Project Special Provisions
(Version 06.5)
Signals and Intelligent Transportation Systems

SHEET 1 OF 3  
1725D01

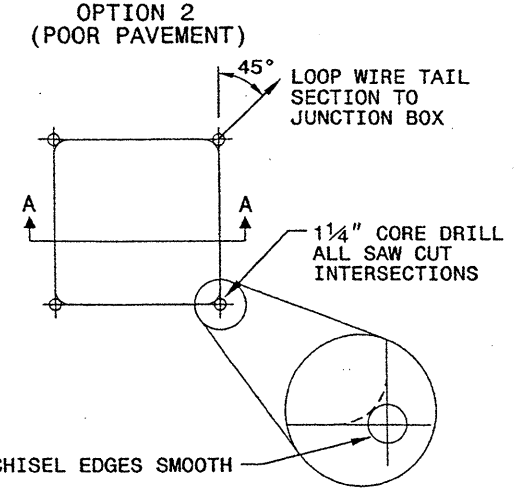
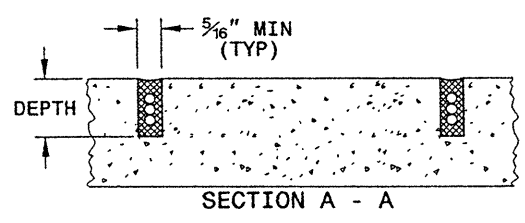
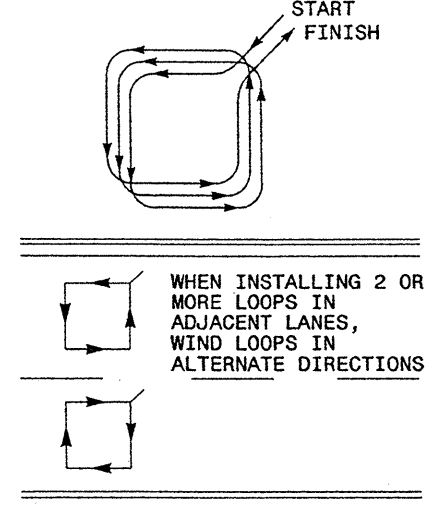
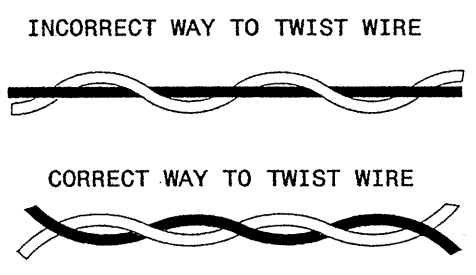
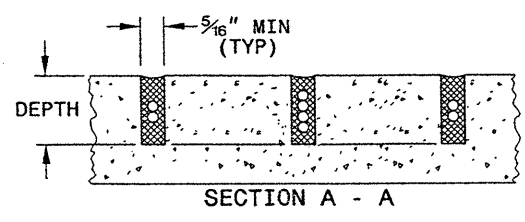
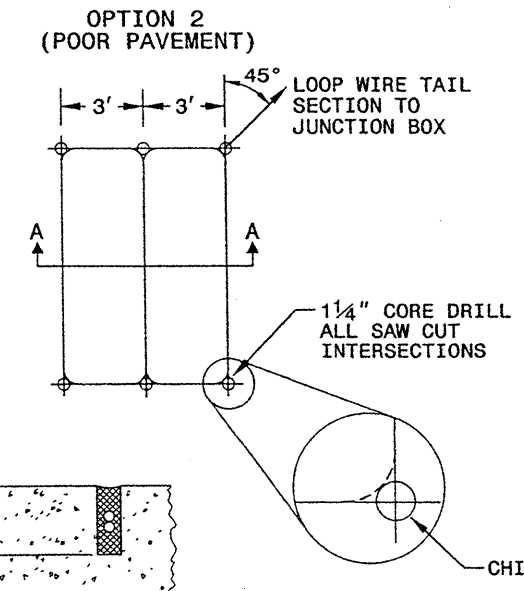
1.4. Inductive Detection Loops – Construction Methods (1725-3)

Page 17-20, Subarticle 1725-3, In the first paragraph on the page, revise the first sentence to:

"Twist loop conductor pairs a minimum of 5 turns per foot from where conductors leave saw slot to junction box.
